Development Facilitation Team (DFT) – Review Comments

Project No: PR-2025-020022 Date: 5/21/2025 Agenda Item: #8 Zone Atlas Page: L-14

Request: Consolidate two existing lots into one, and request DHO determinations from 10ft alleyway width to the North and sidewalk width along Kathryn.

Project Name: 229 Kathryn Ave SE

Plat for
Lot 55-A, Block 3
J.C. Mitchell Addition No. 1
Being Comprised of
Lots 55 and 56, Block 3
J.C. Mitchell Addition No. 1
City of Albuquerque
Bernalillo County, New Mexico
April 2025

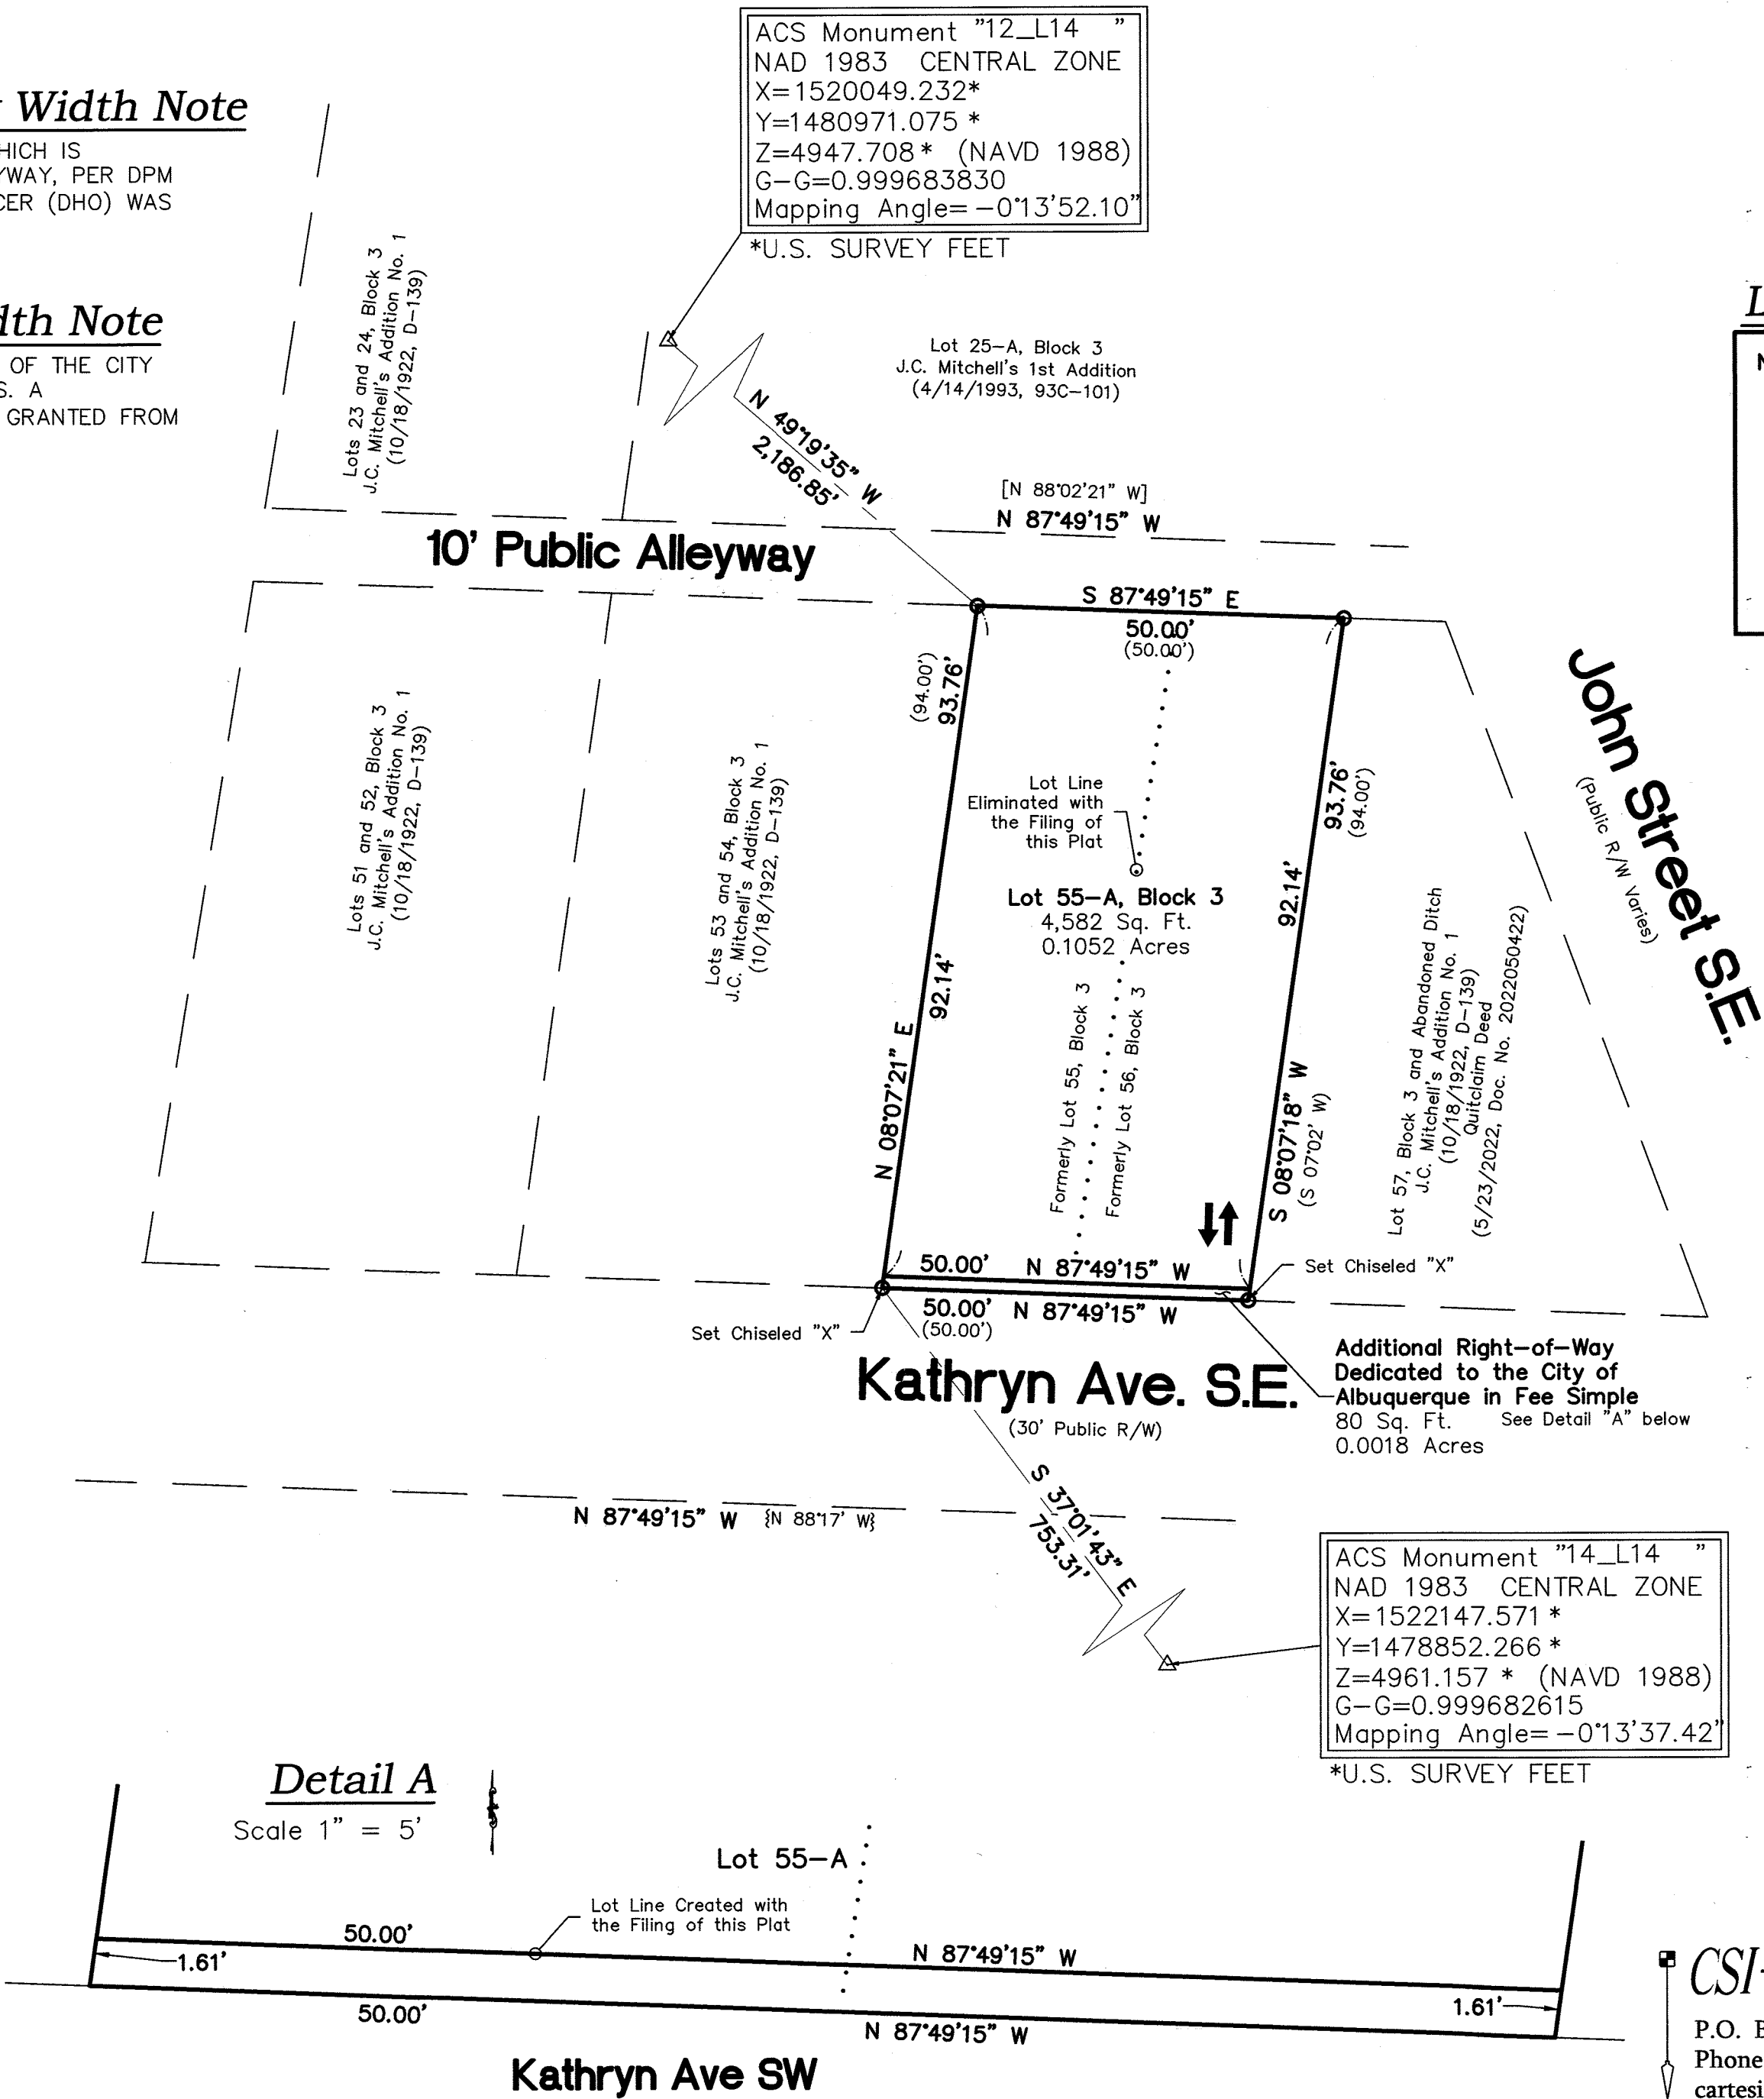
- **A note will need to be included on the plat following determinations approval.**
- Per 6-6(K)(2)(l), the applicant shall record the final plat with the Bernalillo County Clerk within 3 months after the date of the final signature on the plat, or the subdivision shall be voided. The applicant shall provide the City a digital copy of the recorded plat.

Plat for
Lot 55-A, Block 3
J.C. Mitchell Addition No. 1
Being Comprised of
Lots 55 and 56, Block 3
J.C. Mitchell Addition No. 1
City of Albuquerque
Bernalillo County, New Mexico
February 2025

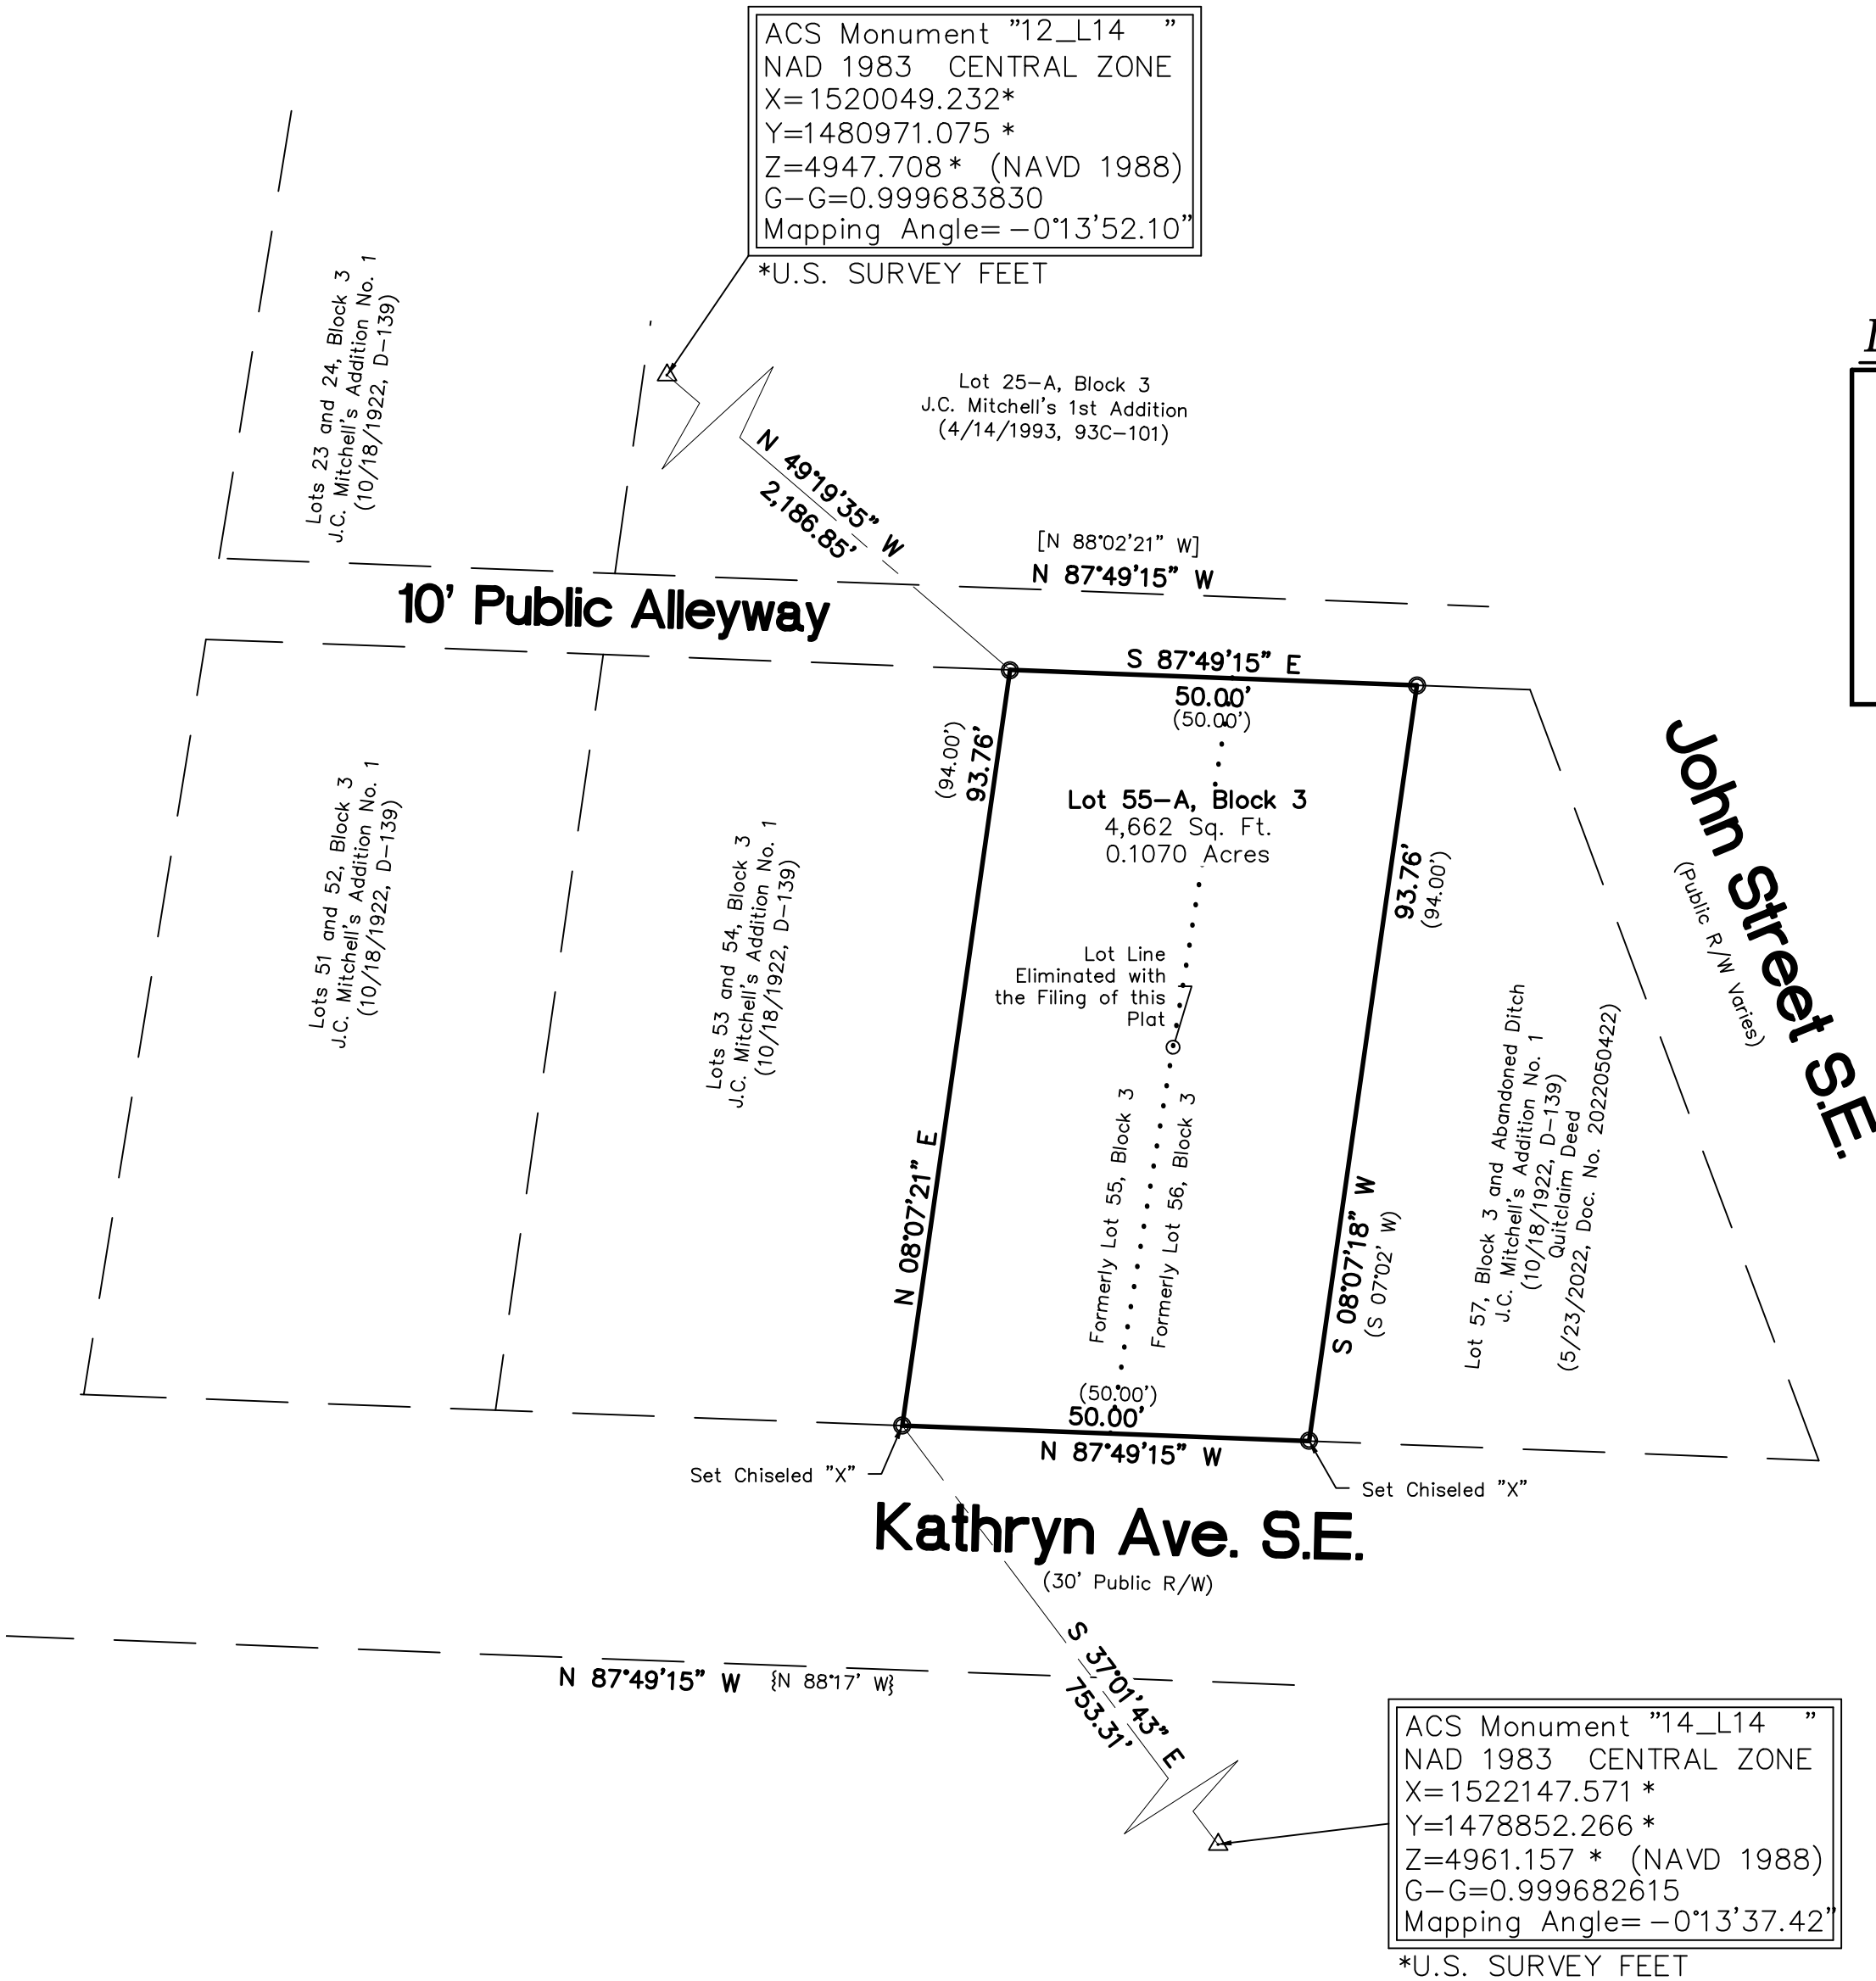
- **Prior to final sign-off of the plat, the AGIS office must approve the DXF file and proof of approval must be provided.**
- **Per 6-6(K)(2)(k), The date of the DHO approval shall be recorded on the Final Plat.**
- **The Application number must be added to the plat.**
- After DHO approval and final sign off, a recorded copy of the plat must be sent to **Jay Rodenbeck** at jrodenbeck@cabq.gov and **Angela Gomez** at agomez@cabq.gov (should the Plat be approved by the DHO).
